Re: Car Wash
720 Wyoming Blvd NE, 87109
Traffic Circulation Layout
Architect's Stamp 06-25-2019 (D19-D005)

Based upon the information provided in your submittal received 07-17-2020, the above referenced plan cannot be approved for Building Permit until the following comments are addressed:

TCL

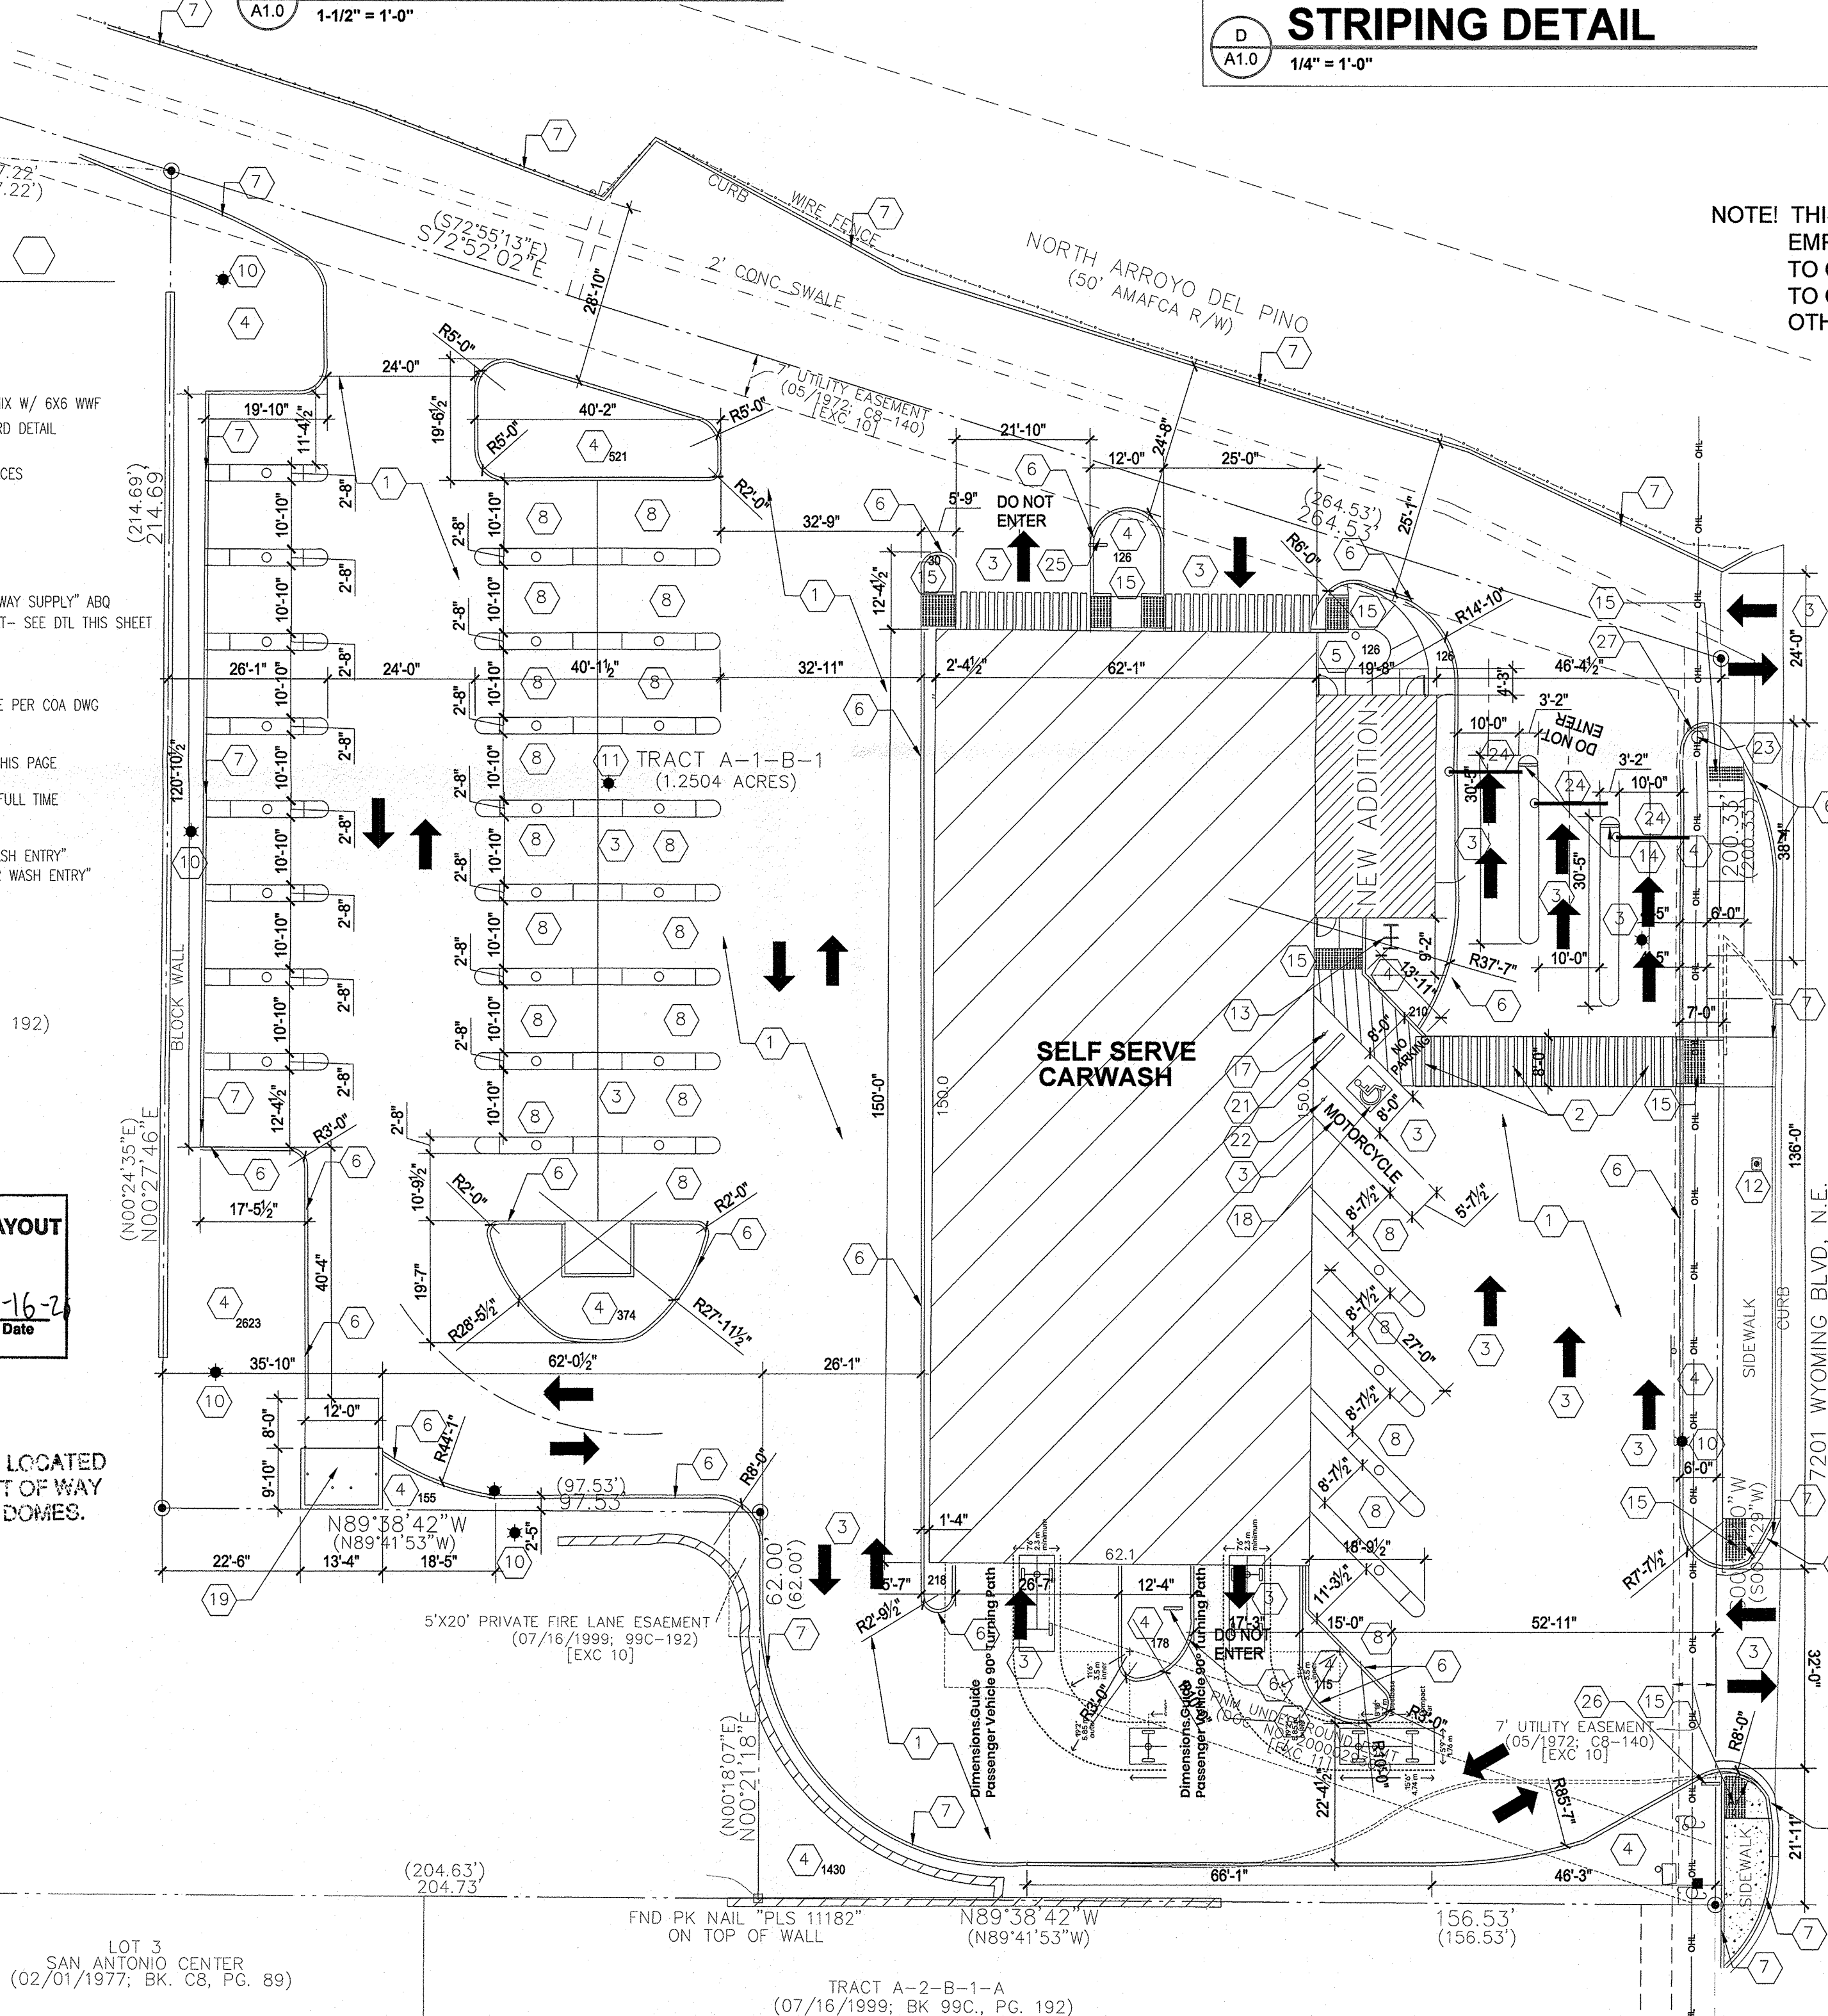
1. The adjusted curb: Provide the size of curb used on both entrances. On the north entrance, need to provide the radii used to the adjusted locations.

2. The radii on the south entrance appear to be a bit small coming off an Arterial, please substantiate that these radii's will function without any problems by providing turning templates exhibit entering and exiting the southern entrance. Please use a delivery vehicle and/or Refuse vehicle for the turning template exhibit.

3. Provide a separate detail for the adjusted ADA wheel ramp (include slopes, dimensions) on the southern entrance.
4. You mention an existing monument sign. Please verify that all of the signage infrastructure is located on private property and this includes airspace. This includes keyed note 26 (custom sign).

5. All ADA wheelchair ramp need to have truncated domes/tactile truncated dome material per Keyed note 15. Please verify that this is the case for all ramps within the COA right-of-way.
